Our ref: RA/2021/143881/01-L01
Your ref: 2021/94208
Date: 20 December 2021

OUTLINE APPLICATION FOR RE-DEVELOPMENT OF FORMER WASTEWATER TREATMENT WORKS, INCLUDING DEMOLITION OF EXISTING STRUCTURES TO PROVIDE EMPLOYMENT USES (USE CLASSES E(G)(II); E(G)(III); B2 AND B8). FORMER NORTH BIERLEY WASTEWATER TREATMENT WORKS, CLIFF HOLLINS LANE, OAKENSHAW, BD12 7ET

Environment Agency position

In the absence of an acceptable Flood Risk Assessment (FRA) we object to this application and recommend that planning permission is refused.

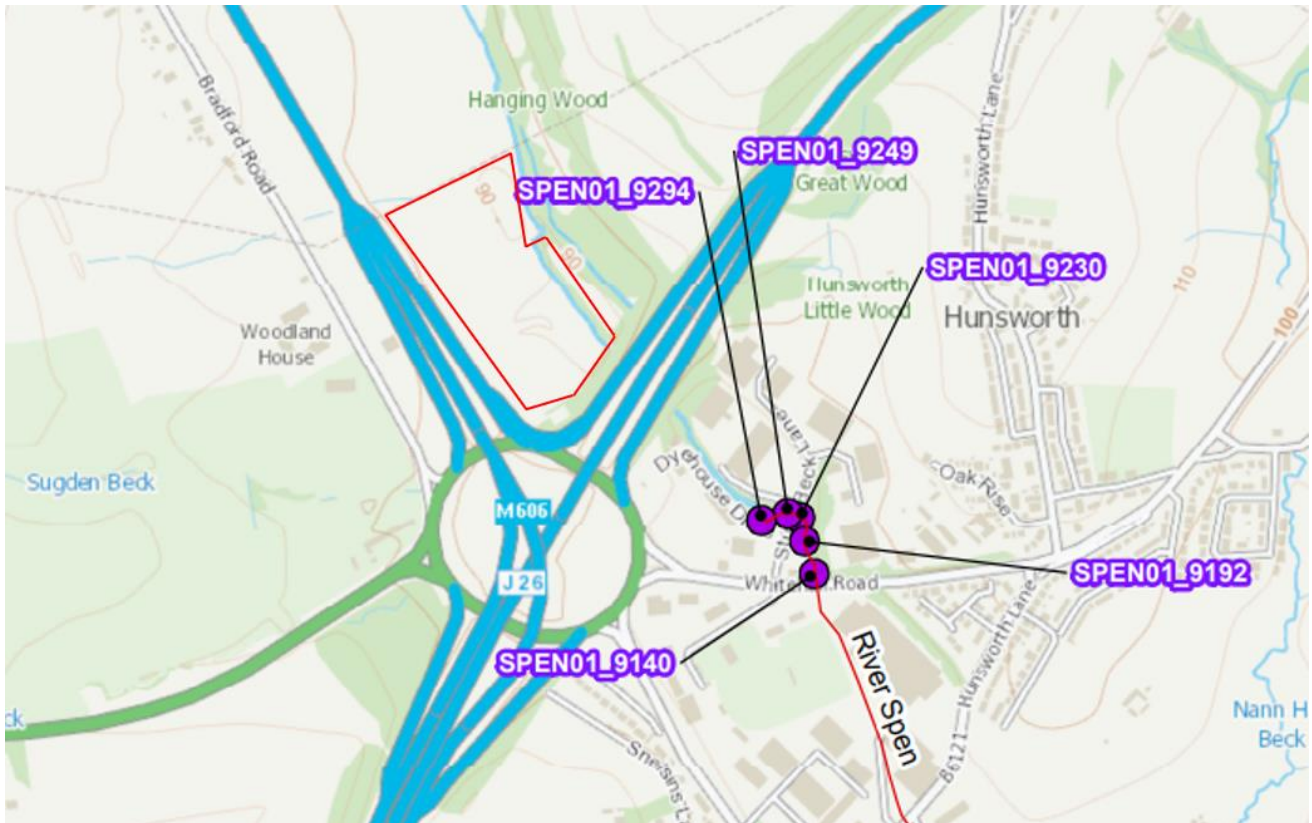
The majority of the site lies in Flood Zone 1, however, there is an area of Flood Zones 2 and 3 within the red line boundary and close to the development.

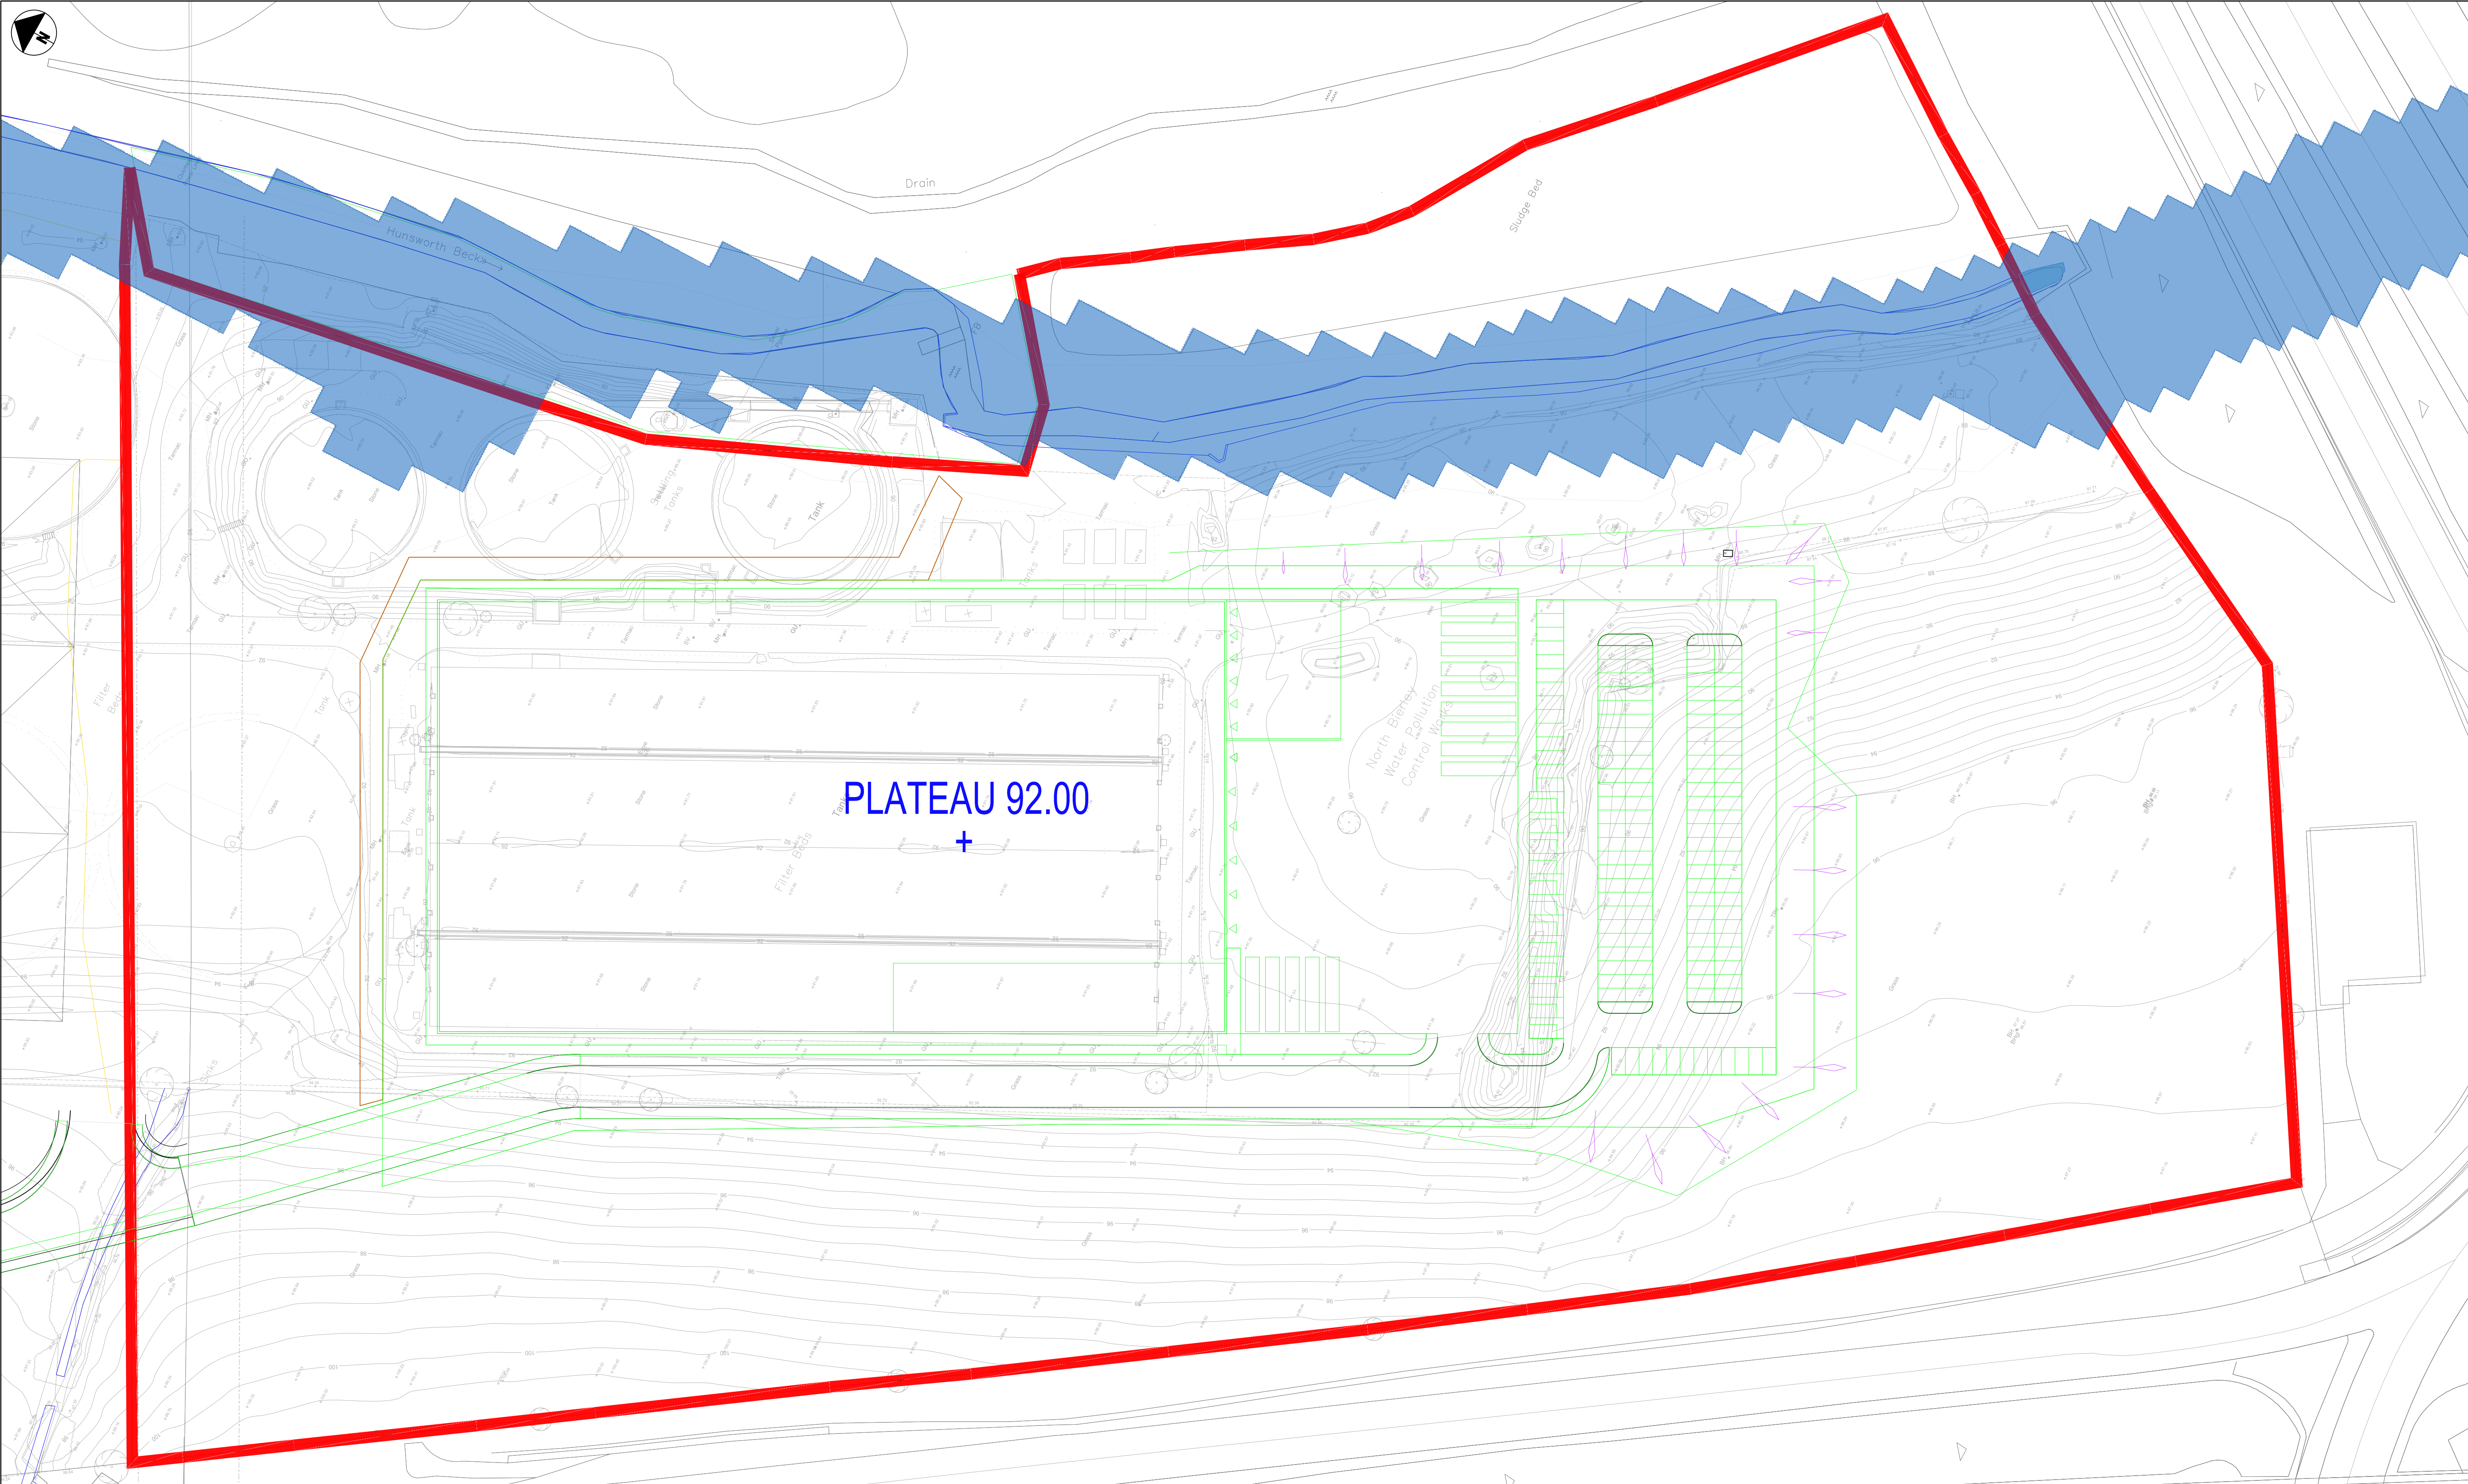
We expect to see finished floor levels set a minimum of 600mm above whichever is greater of existing ground level or design flood level, or 300mm if the design flood level already takes into account Climate Change.
